Subject: RE: WA/11/19/DOC - Land east of Tye Lane, Walberton - Condition 19 regarding the location of fire hydrants

Please find attached a copy of the revised Hydrants Plan for Land East of Tye Lane, Walberton.

WALBERTON
LAND EAST OF TYE LANE

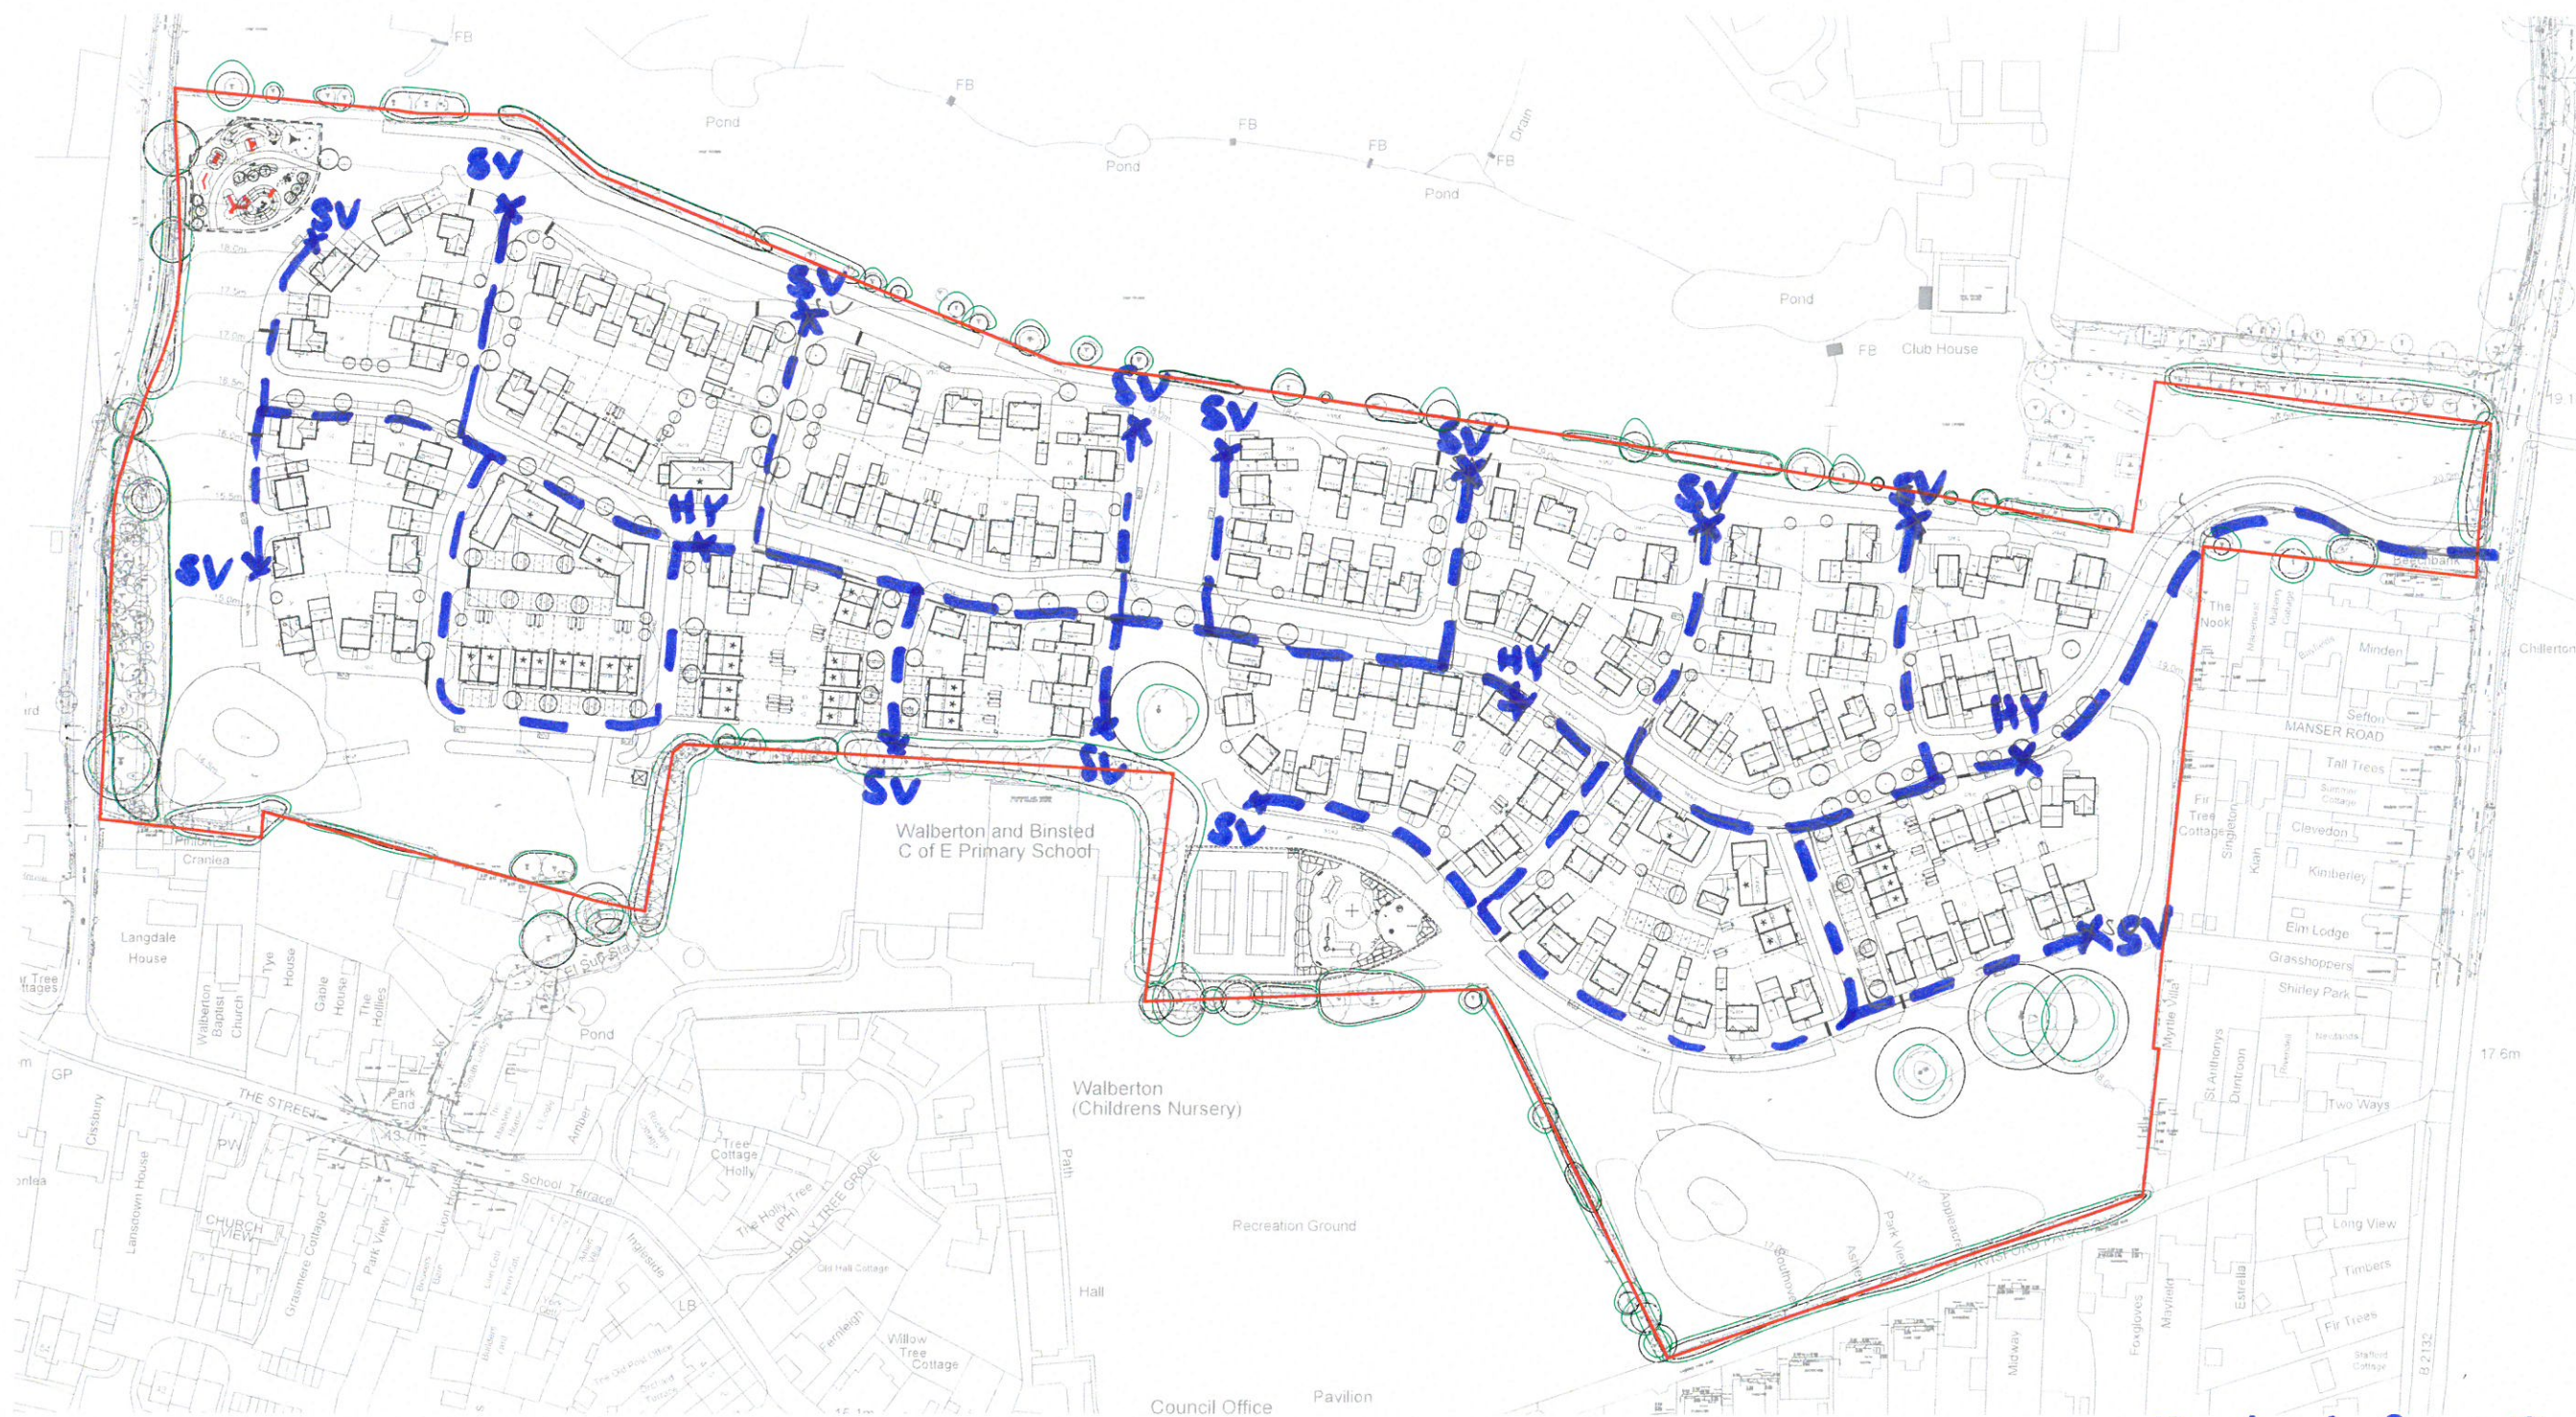
Thank you for the revised drawing to comply with the initial requirement. The submitted plan would suffice to comply with condition 19.

As the site starts to take a formal design we would request an update and as the site will be developed in stages we would need to be informed to inspect the hydrants as they become operational to ensure they are fit for purpose prior to occupation. This is common practice on larger sites.
